October 18, 2021

**Re: Apple Canyon Gourmet – 1301 Cuesta Abajo Ct NE
Erosion and Sediment Control Plan for Demolition
Engineer's Stamp Date: 10/18/2021 (D16E002H)**

SHEET NO.  
C-101

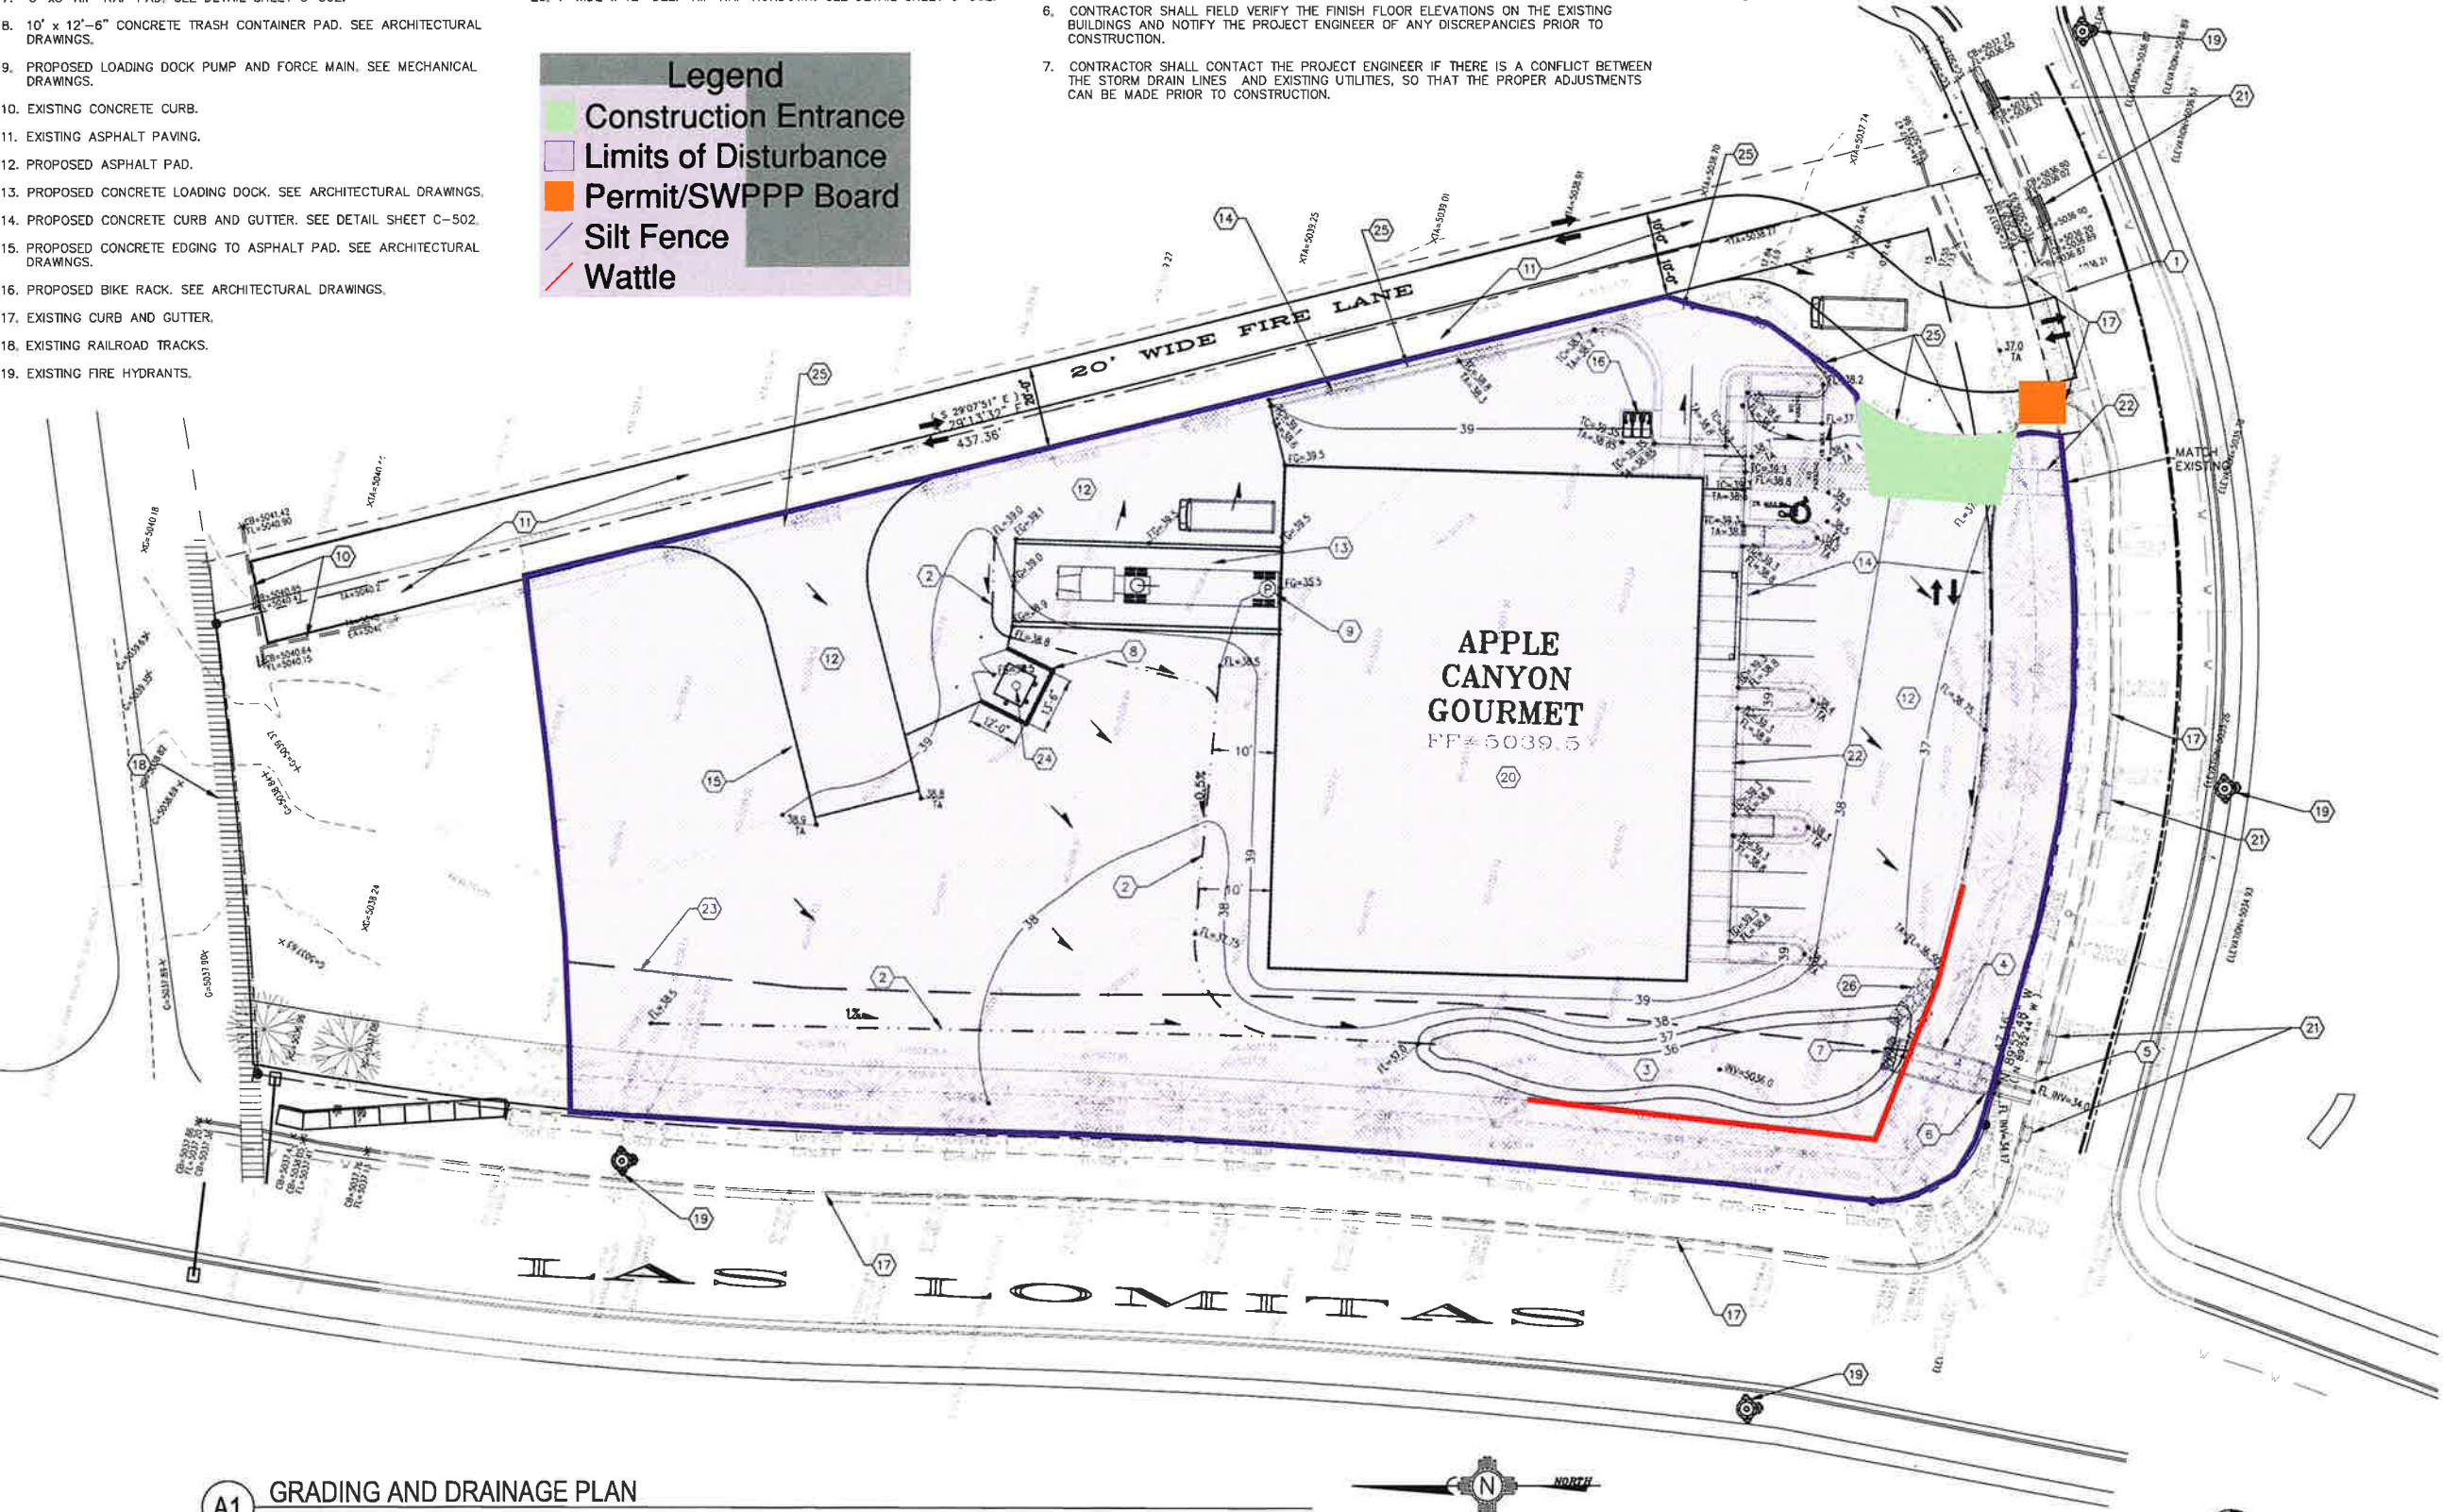
1. The native seeding specification doesn't satisfy the Final Stabilization Criteria, Part 12.2.14.b of the Construction General Permit unless Agregate mulch is used instead of the specified hydromulch on the Landscape Plan. Either change the mulch specification or add a discussion of the required BMPs, inspections, and maintenance that the seeded area will require until the density of the perineal vegetation reaches 70% of the Natural undisturbed density. Add these additional specifications to the ESC Plan in the SWPPP and e-mail to me and identify the required density of ground cover if growing vegetation instead of providing Agregate Mulch.
2. Extend the area of disturbance and silt fence to the north property line to match the Site Plan and Landscape Plan. E-mail a copy of the updated ESC Plan to me and update the SWPPP.
